8 December 2025

Re: Forest Lodge Integrated Seniors Living (SSD-75493483) – Response to Submissions

In accordance with the Department’s Request for Additional Information dated 2 October 2025, this letter is provided to address the key issues and comments raised by the Department, City of Sydney and the agency advice received in response to the Environmental Impact Statement for SSD-75493483.

Detail Plan 2 - North Western Boundary Site Through Link & Port Cochere

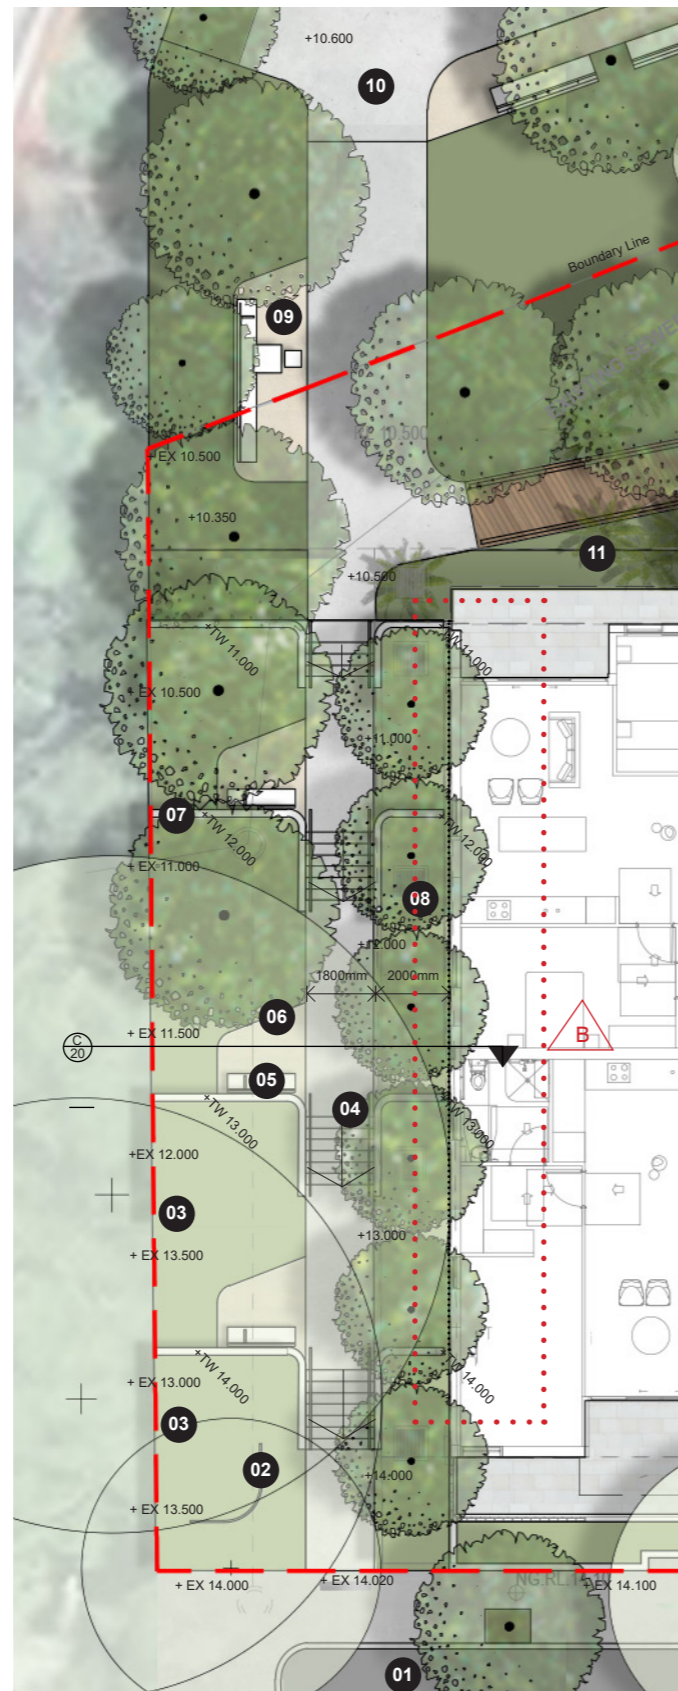
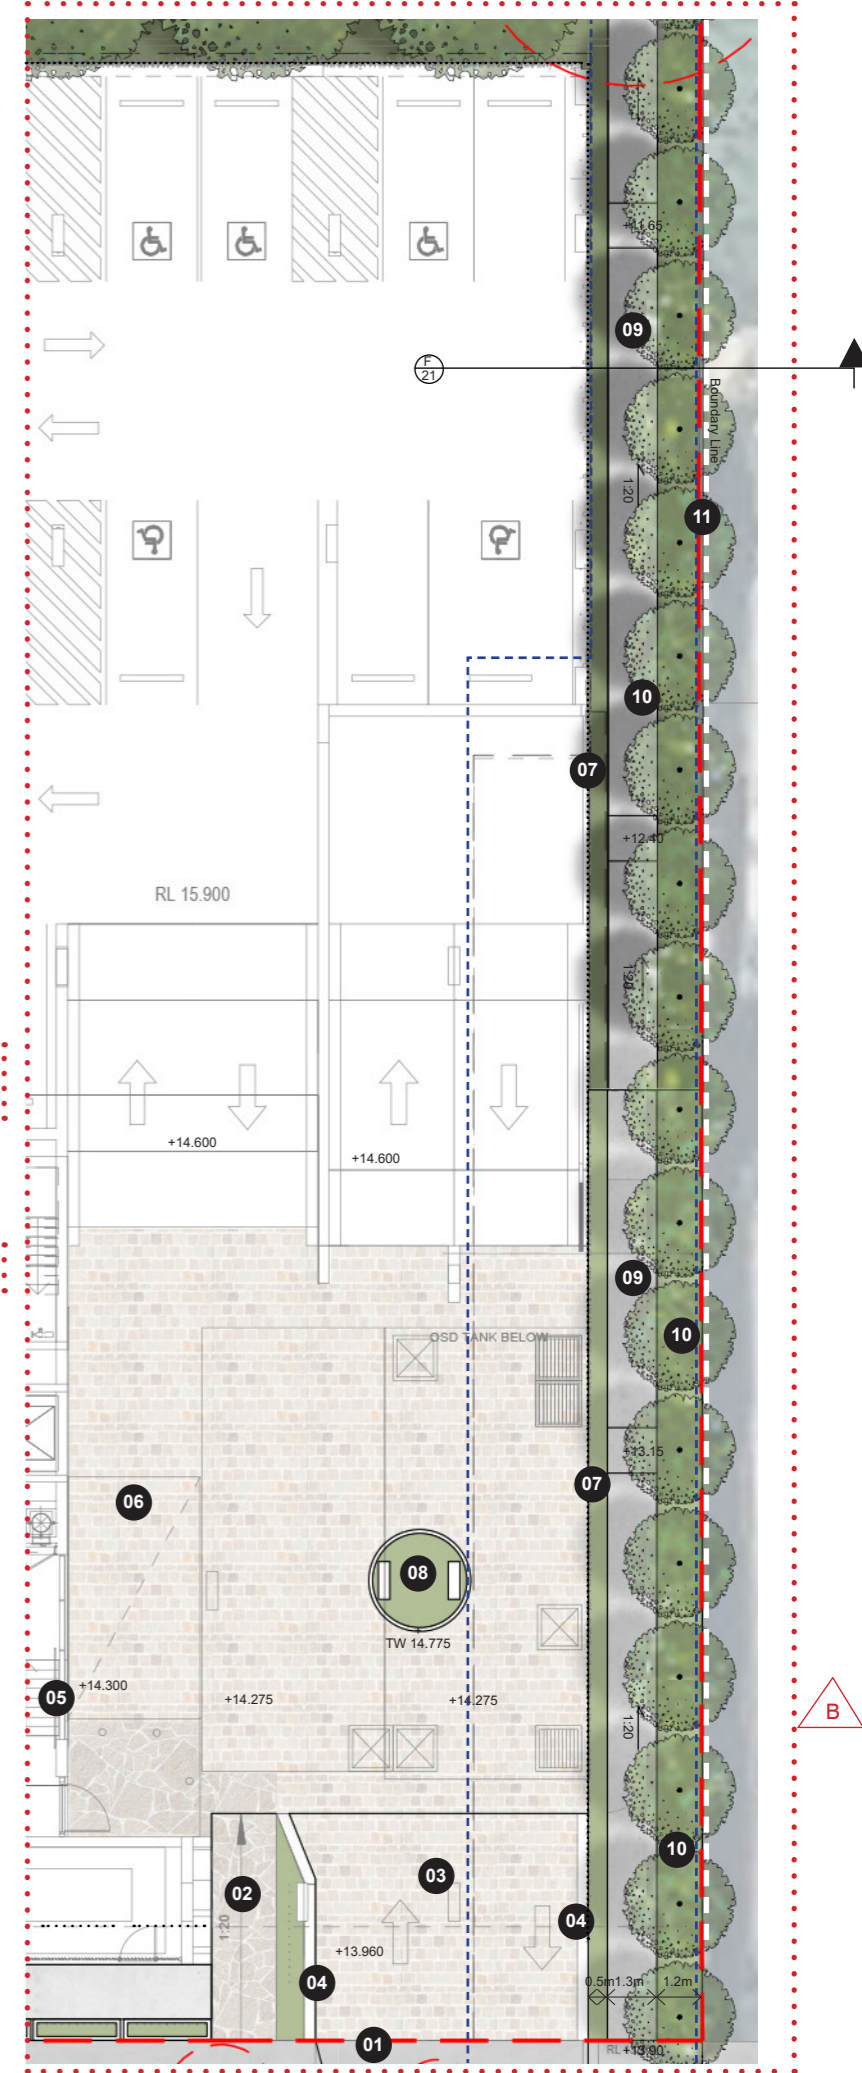
| Landscape Architecture | <p><i>The northwestern through-site link (Area F) must achieve a minimum width of 3m to provide sufficient space for pedestrian access path and mature screen planting along the entire length of the through-site link as required</i></p> |

by section 6.3.12.5(7) of the Sydney SDCP 2012. The grades of the through-site link are to comply with AS1428.

A direct connection between the northwestern through-site link and the existing footpath to Orphan School Creek should also be considered to serve the desire line for people travelling to/from Orphan School Creek.

The northwestern site through link is now 3m wide, divided into a 500mm planting strip with climbers traversing the architectural battens, a 1.3m wide walkway at 1:20, and a 1.2m strip of screening planting at the boundary, consisting of Magnolia trees and shade tolerant plants.

A direct connection has been designed to accommodate the desire line between the site through link and existing footpath to Orphan School Creek. Details for this can be found in the landscape report on page 14.

Memory Garden / RAC COS Character

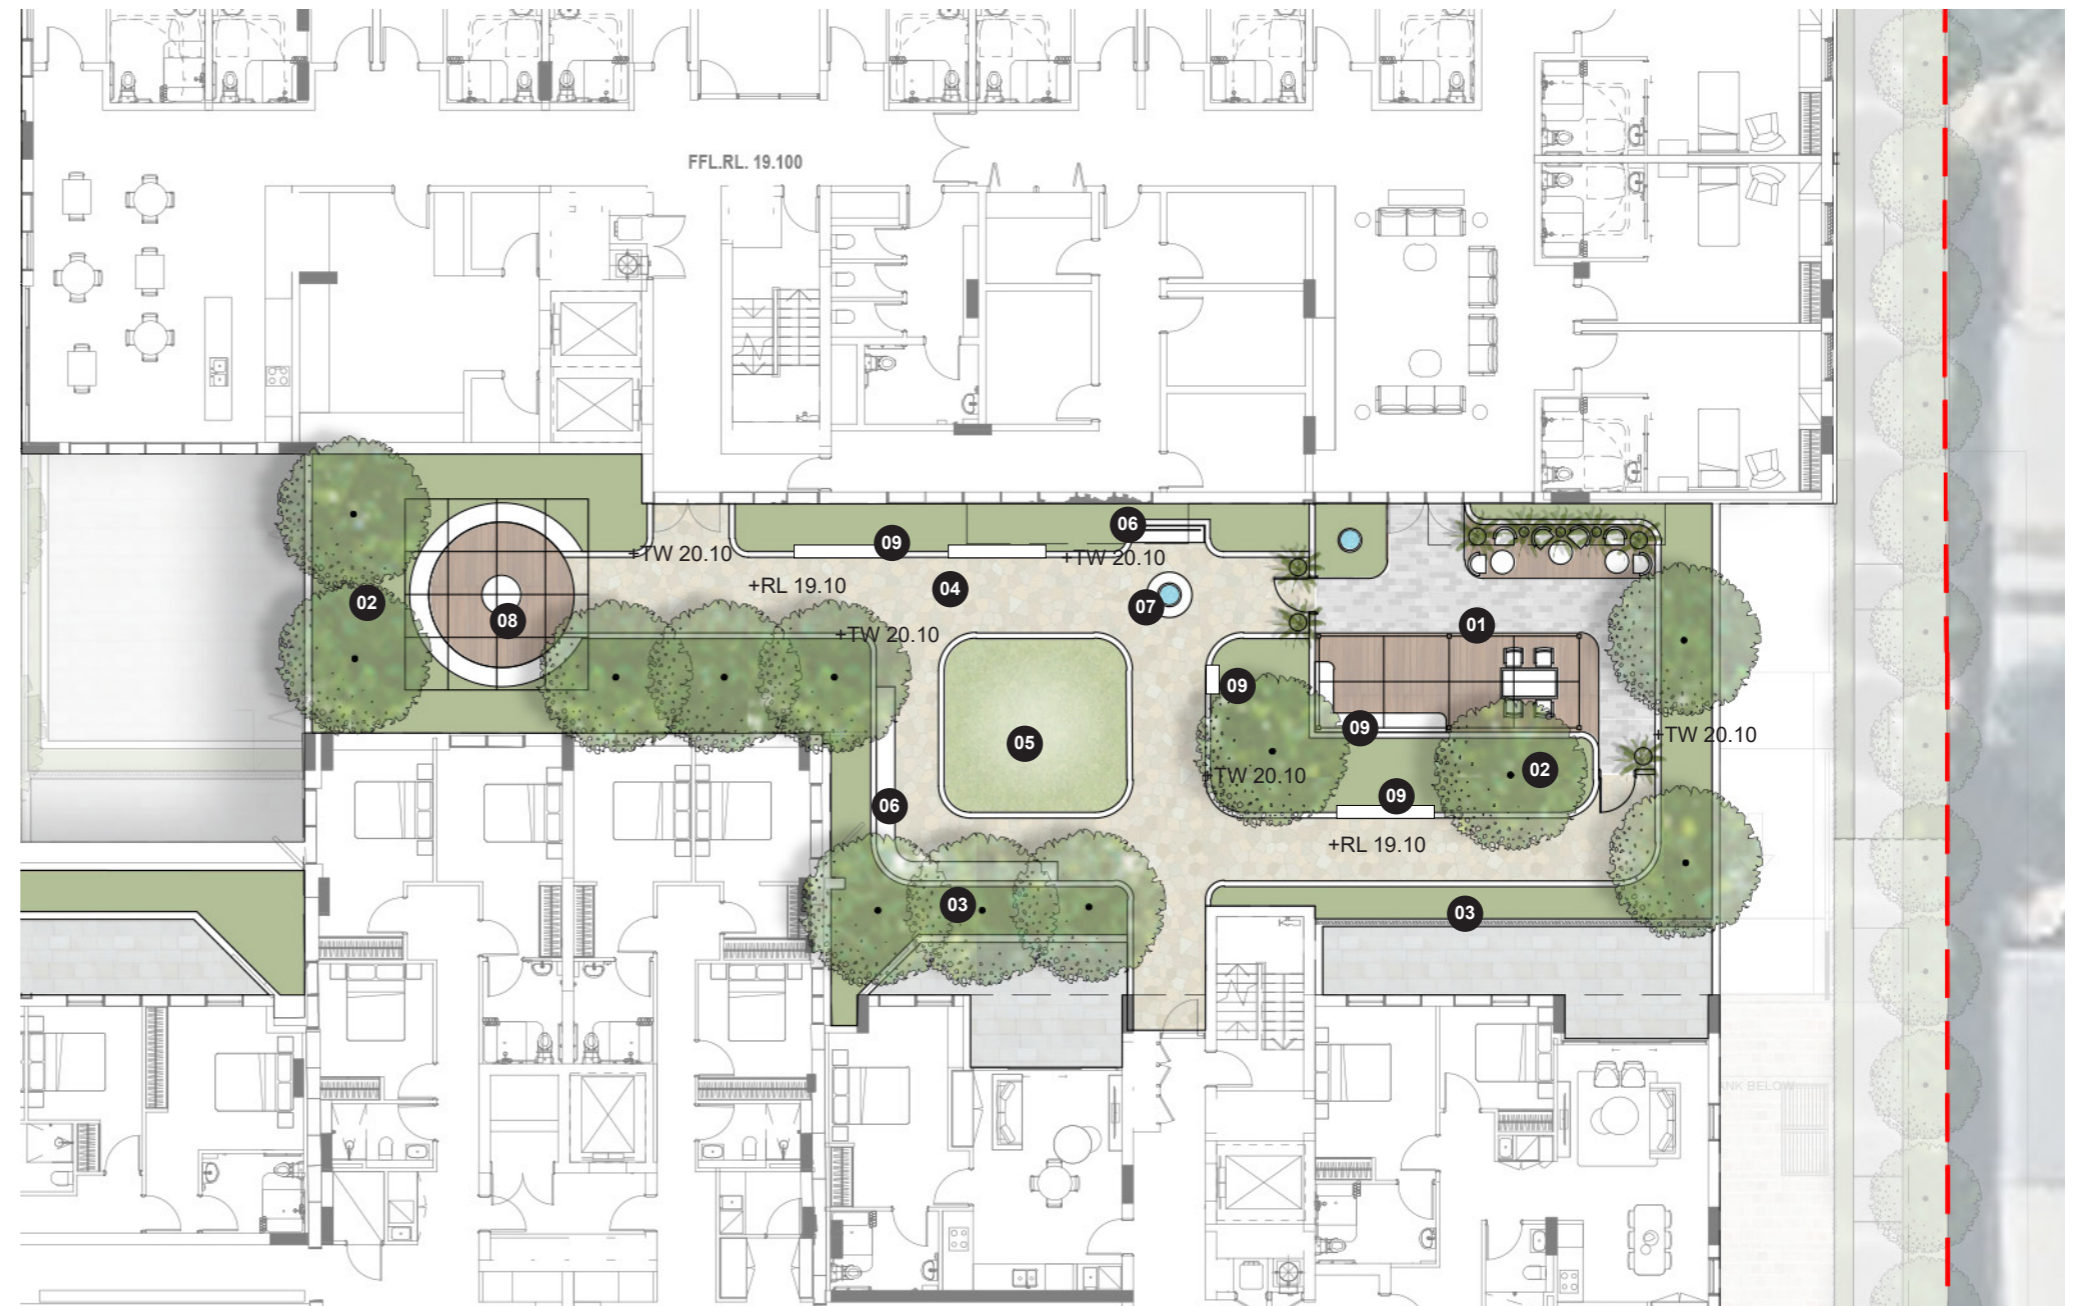
The level 1 planter bed along the northwestern side of the memory garden should achieve a width of 2m, if possible, to afford the proposed pear trees sufficient space to grow to their expected mature sizes.

The highlighted planter on Level 1 is proposed to feature two small Magnolia trees [Magnolia "Little Gem" 6x3m] replacing the previously

| | <p>nominated Pear species. The planter provides a total soil volume of 21.12m³ (min 800mm soil depth over an area of 26.4m²). Based on the ADG guideline of 9m³ of soil per small tree, we consider this to provide ample soil volume for the two proposed small trees, and therefore do not believe it is necessary to increase the planter width to 2m. Increasing the planter width would also significantly reduce the size of the usable communal open space for the residents which we do not agree with.</p> |
